# Appeal Decision

## Appeal Ref: APP/R5510/D/23/3323974

### 32 Wyre Grove, Hayes UB3 4PJ

- The appeal is made under section 78 of the Town and Country Planning Act 1990 against a refusal to grant planning permission.
- The appeal is made by Mr Naresh Kumar against the decision of the London Borough of Hillingdon.
- The application Ref.26480/APP/2023/512 dated 22 February 2023, was refused by notice dated 19 April 2023.
- The development proposed is "first floor side and part rear extension".

AS PROPOSED PLANS AND ELEVATIONS

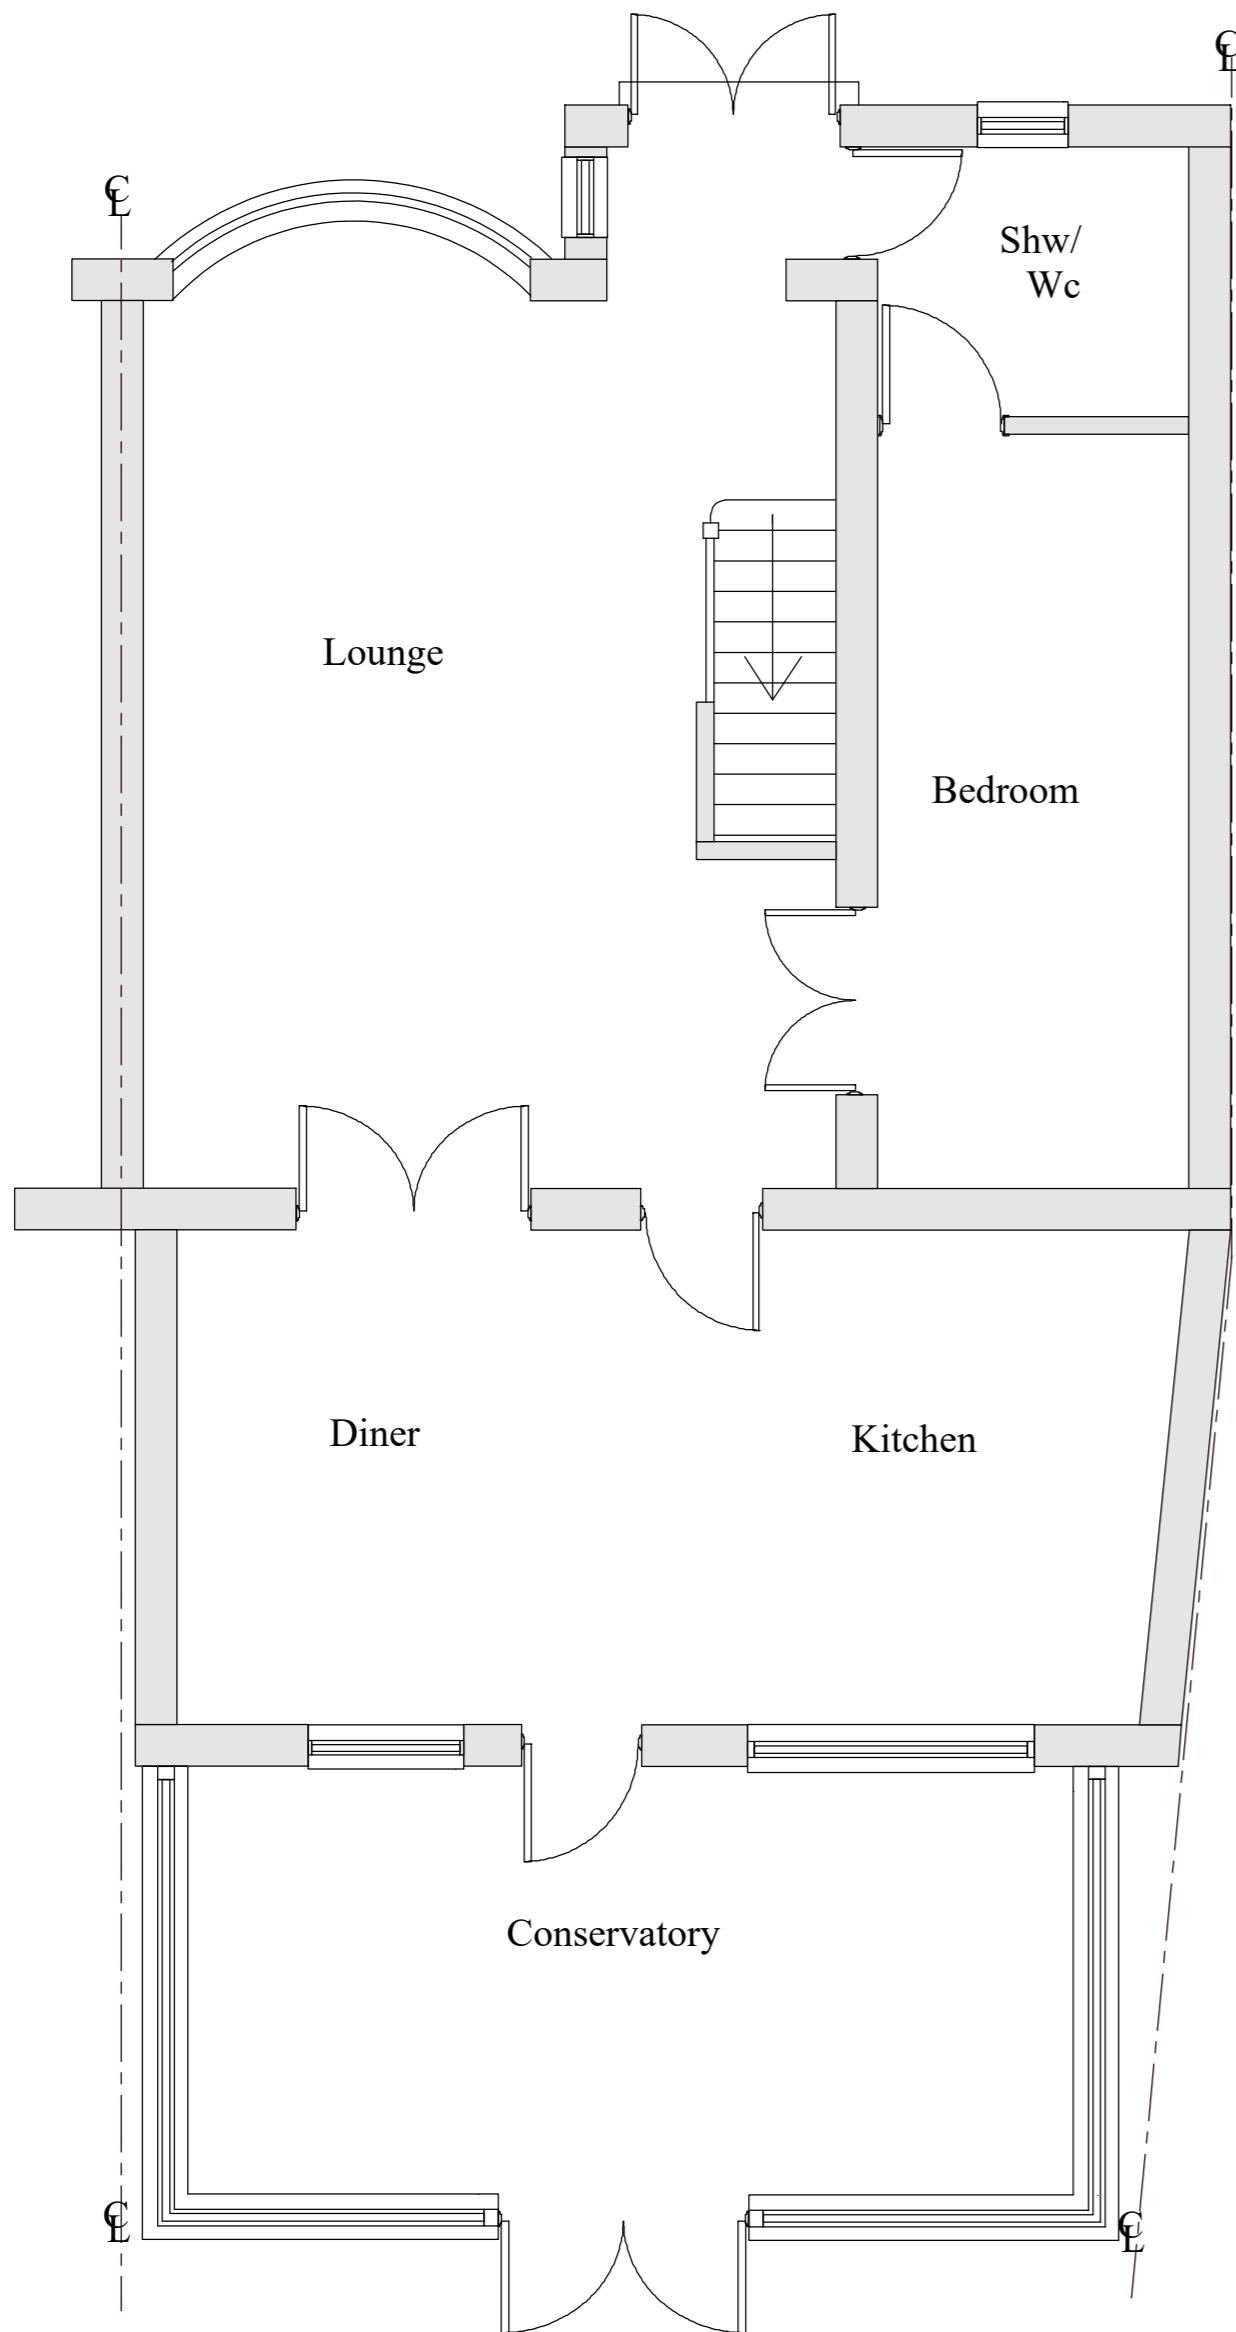
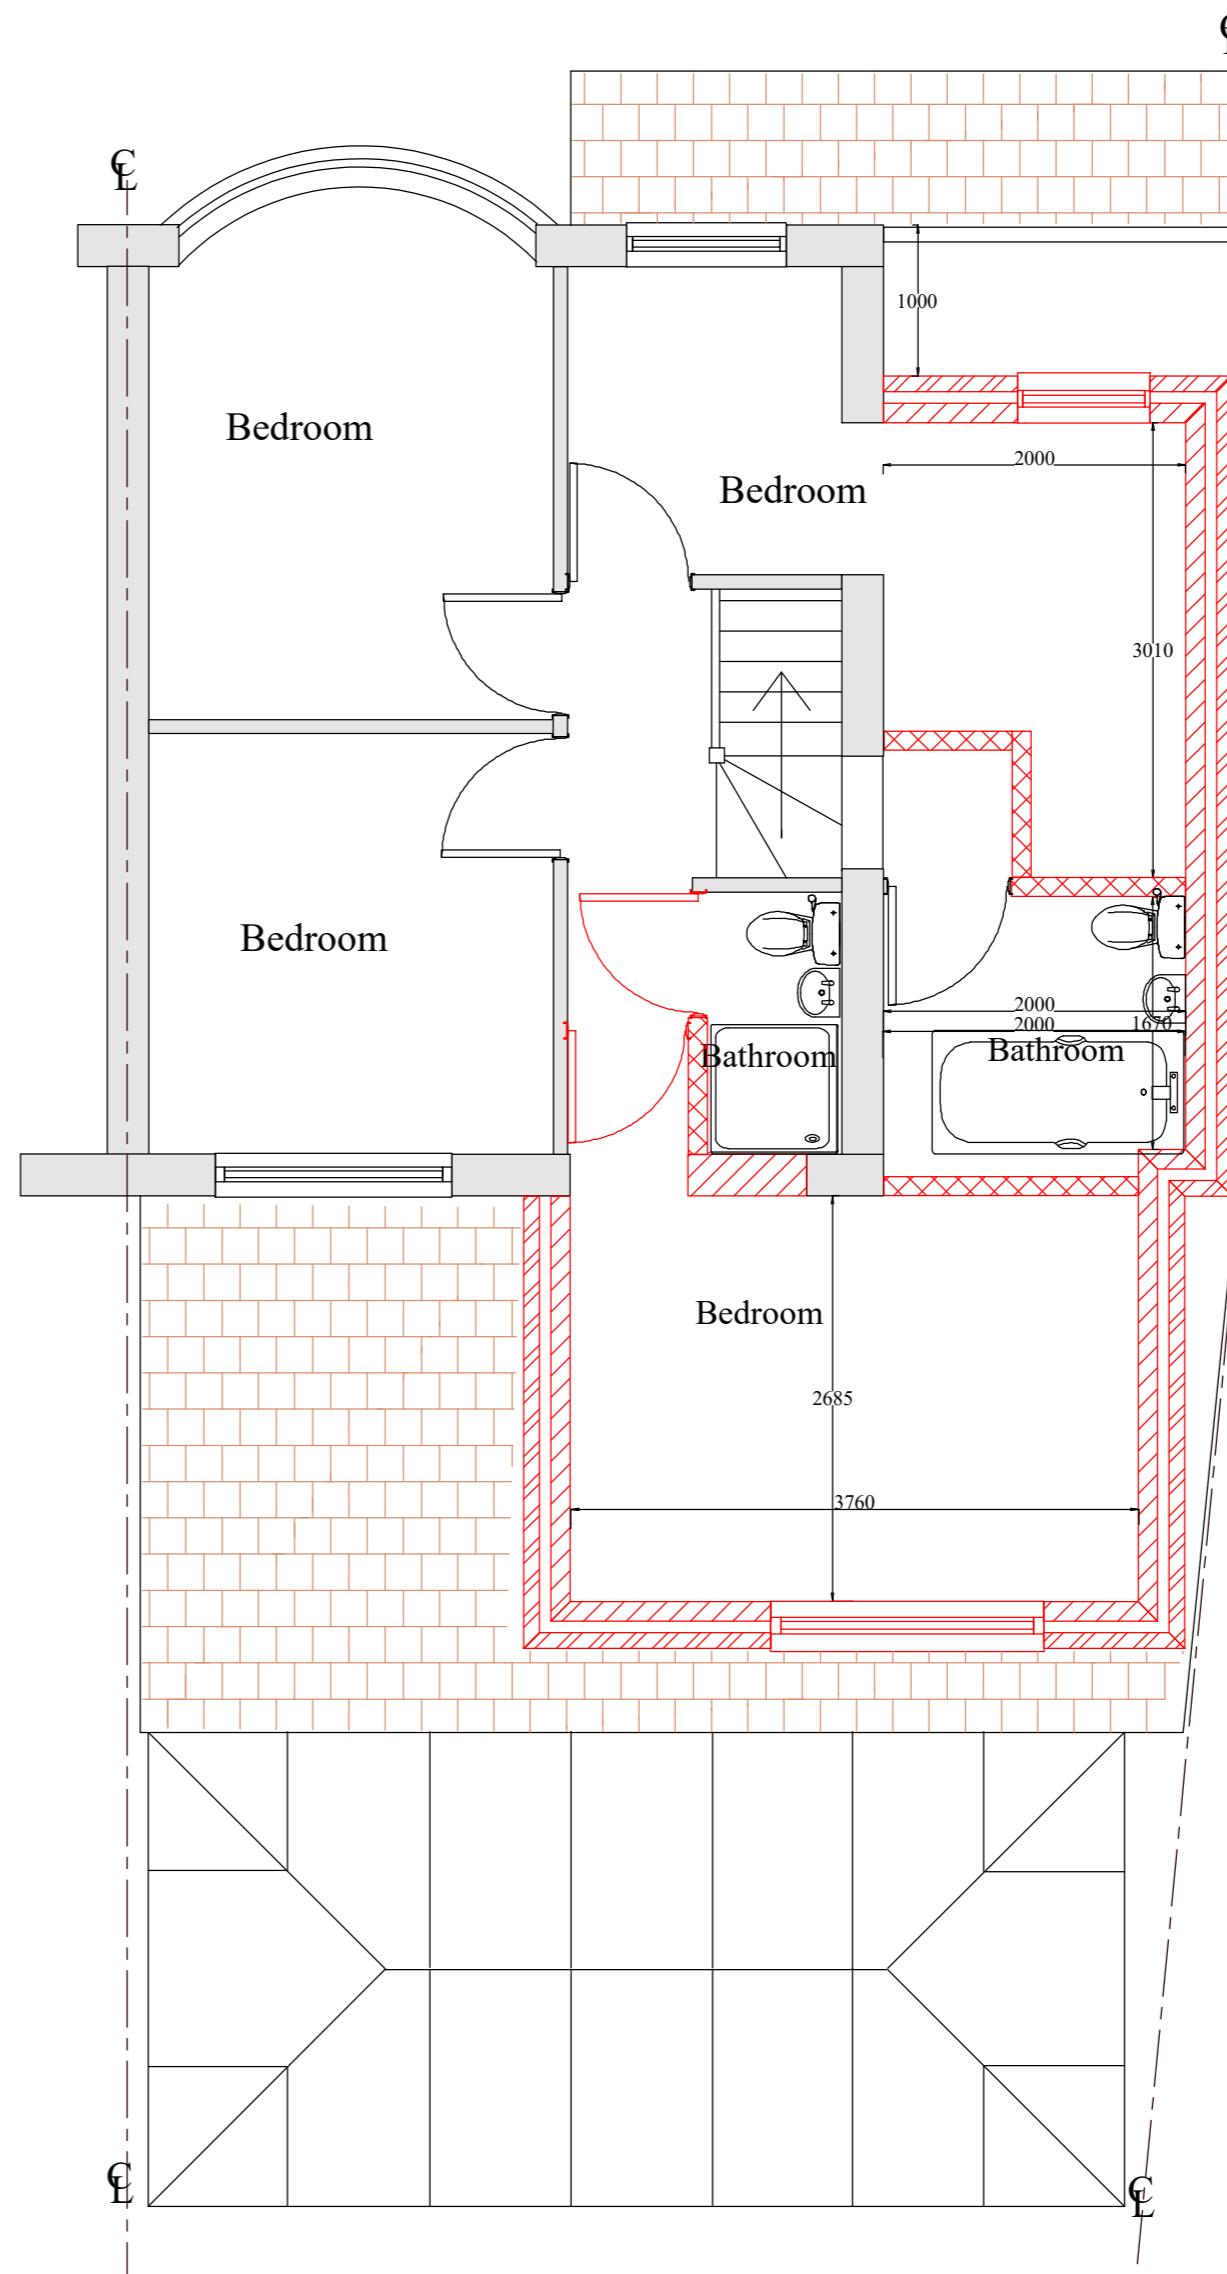
6. The proposal involves the erection of a first floor side/part rear extension with a new gable end roof at the front of the property with a hipped roof behind. The gable end of the roof would be located on the common boundary with no.34. The first floor rear extension would wrap around behind the proposed first floor side extension almost matching the width up to the boundary. It would be set down from the original roof ridge and would have a hipped roof form.

7. Whilst the proposed first floor side extension would be set back from the front elevation of the dwelling, it would not be set down at all from the roof ridge or set in from the common boundary. From the front, the proposal would entirely remove the gap which exists at first floor level between nos 32 and 34. This would continue to be the case to a similar (but not identical) degree if the fallback development permitted by the Certificate was constructed. The spacing would be lost and this currently gives the host property its own identity and distinctiveness and marries it with its semi-pair. Even with the fallback development implemented I consider that these characteristics would endure. The gap also contributes to the openness of the streetscene. I note that policy DMHD 1 encourages a minimum one metre gap from the side boundary and whilst this is not possible at ground floor level, it is in this particular case an appropriate minimum for a first floor side extension.

# AS PROPOSED PLANS AND ELEVATIONS

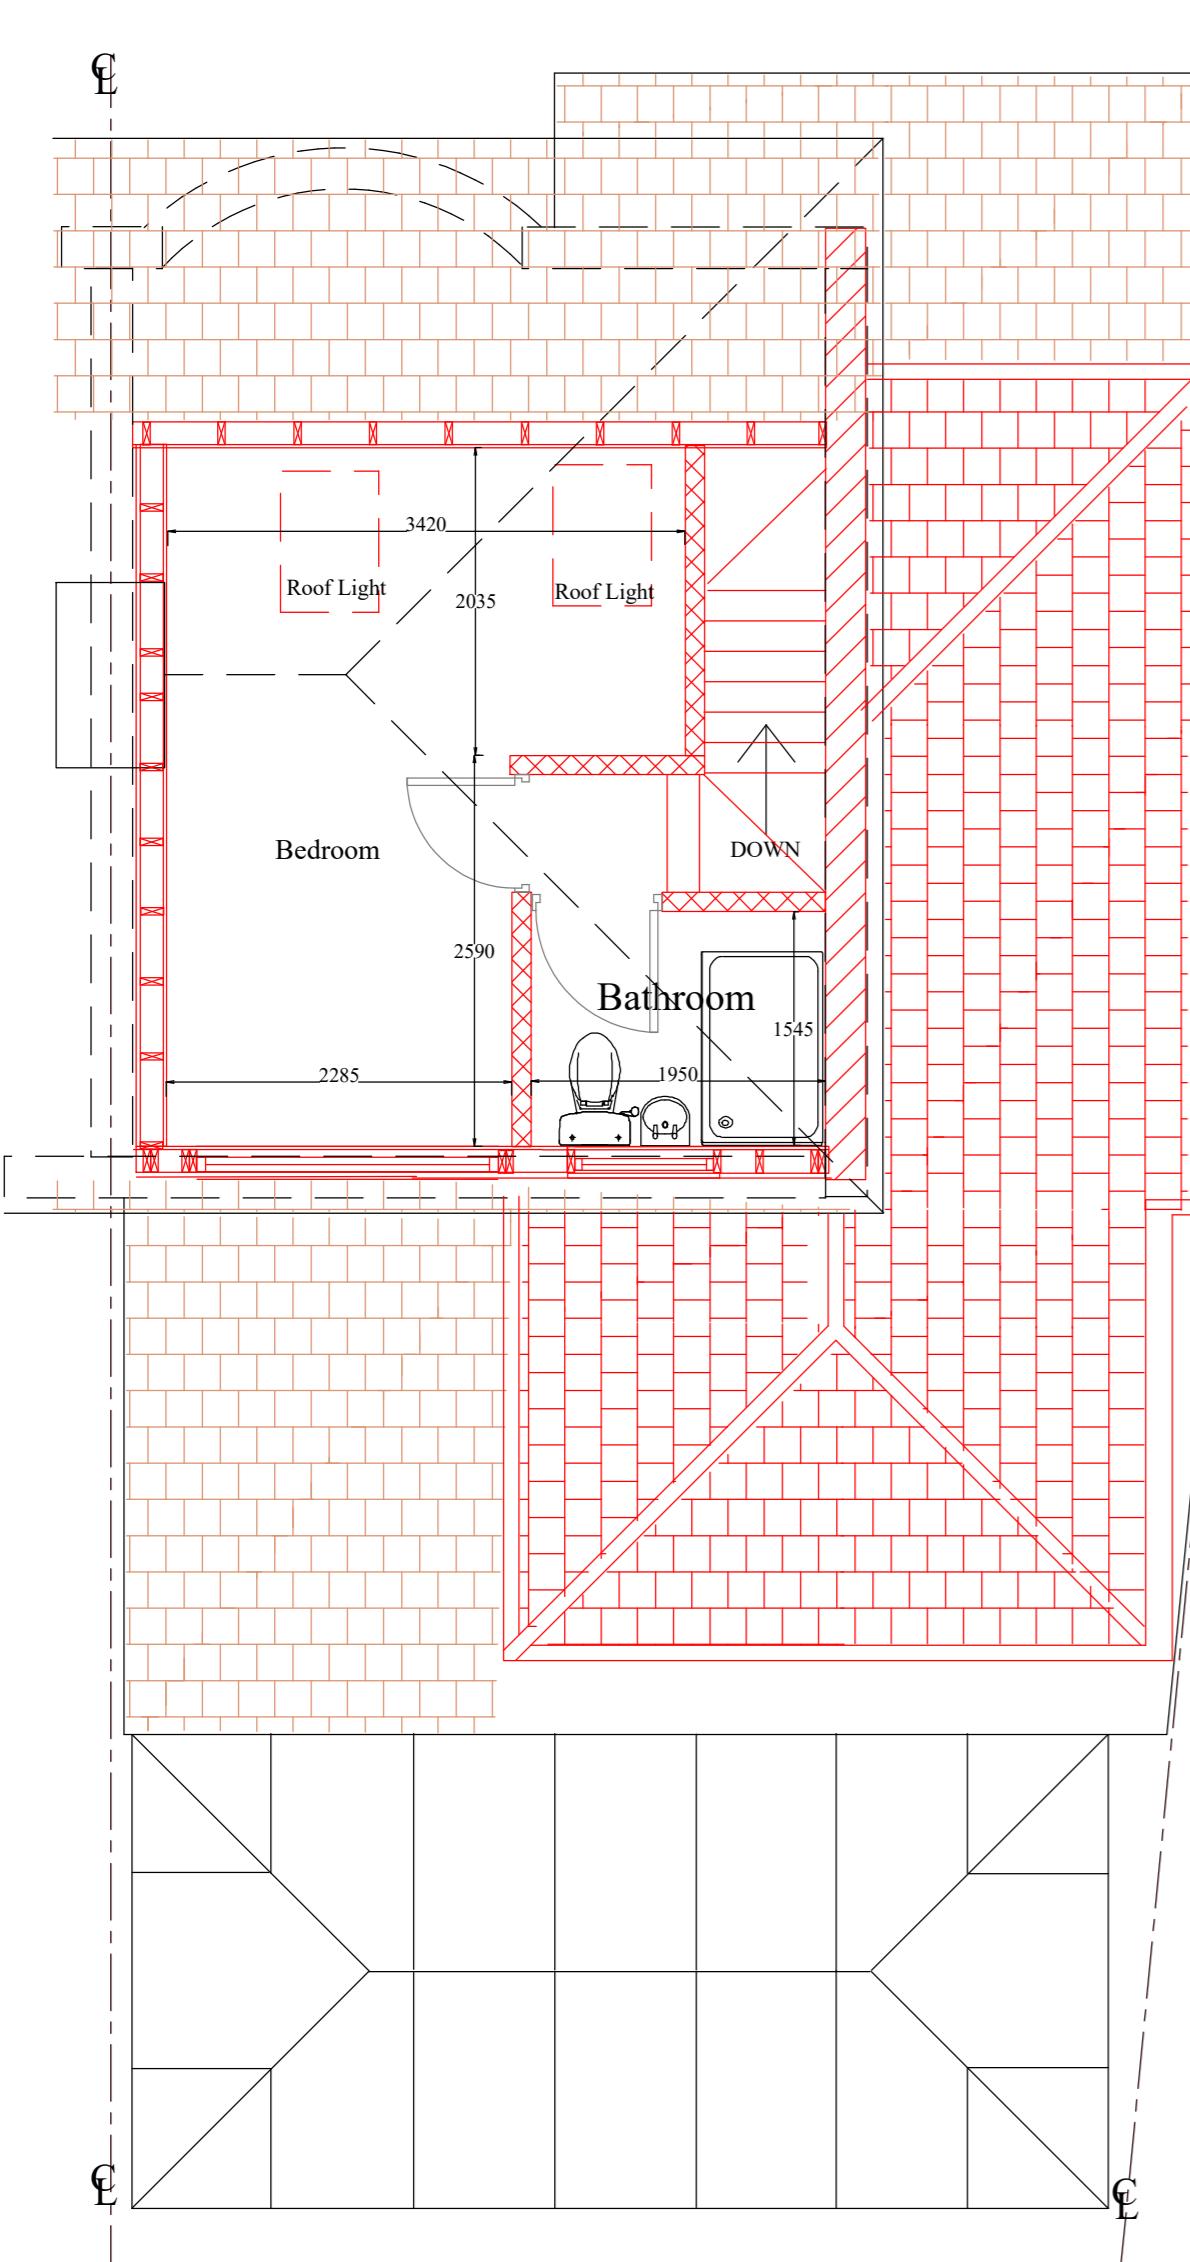
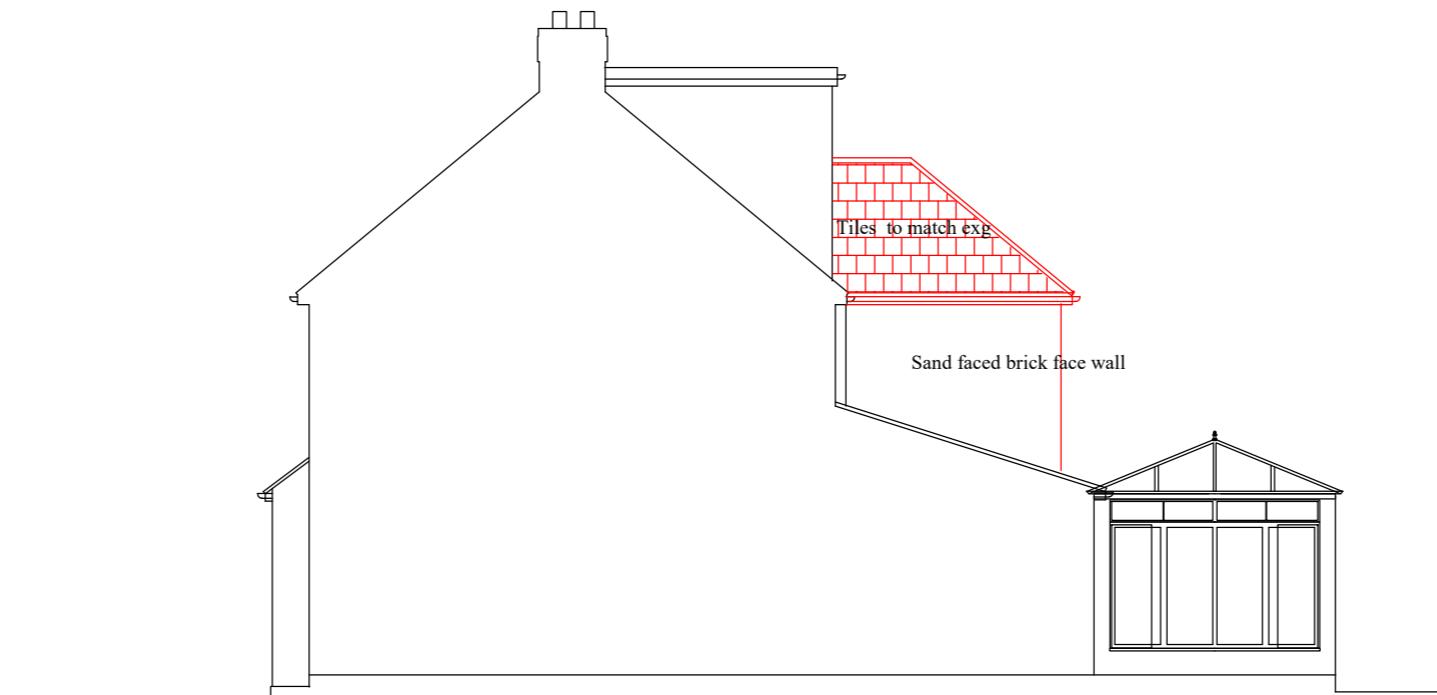
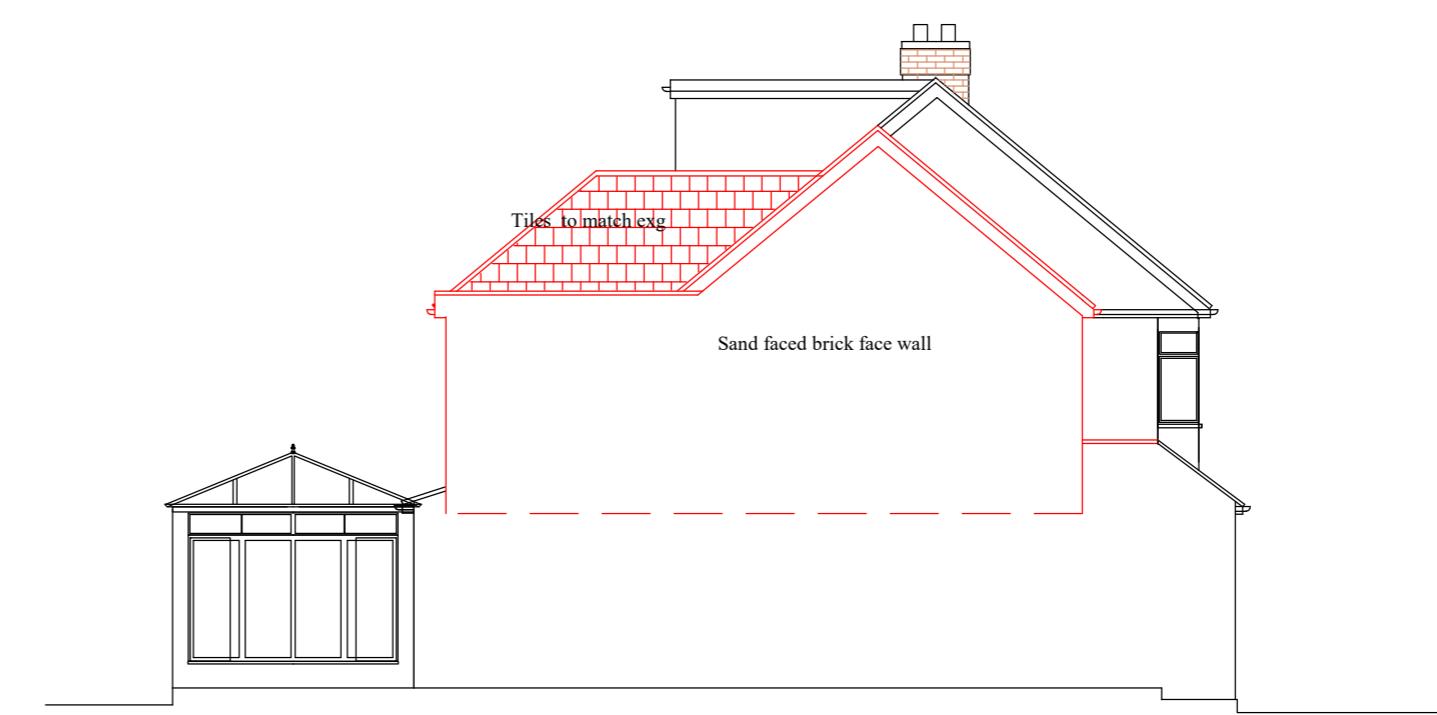
9. I am also concerned that the roof form of the linked hipped roof at the rear of the property would add an additional shape of roof which, when taken with dormer structure, would result in a complicated and distracting design.

11. Given the height and depth of the proposed side elevation of the scheme and its location along the common boundary with no.34 Wyre Grove, it would appear overbearing for the occupants of no.34 when arriving at their front door and when using their front forecourt and, to a lesser extent, their rear garden. It would give an undue sense of enclosure as well as being a plain blank façade and overbearing.
12. On this issue, I conclude that the proposal would harm the living conditions of the occupants of 34 Wyre Grove by reason of loss of outlook. It would be
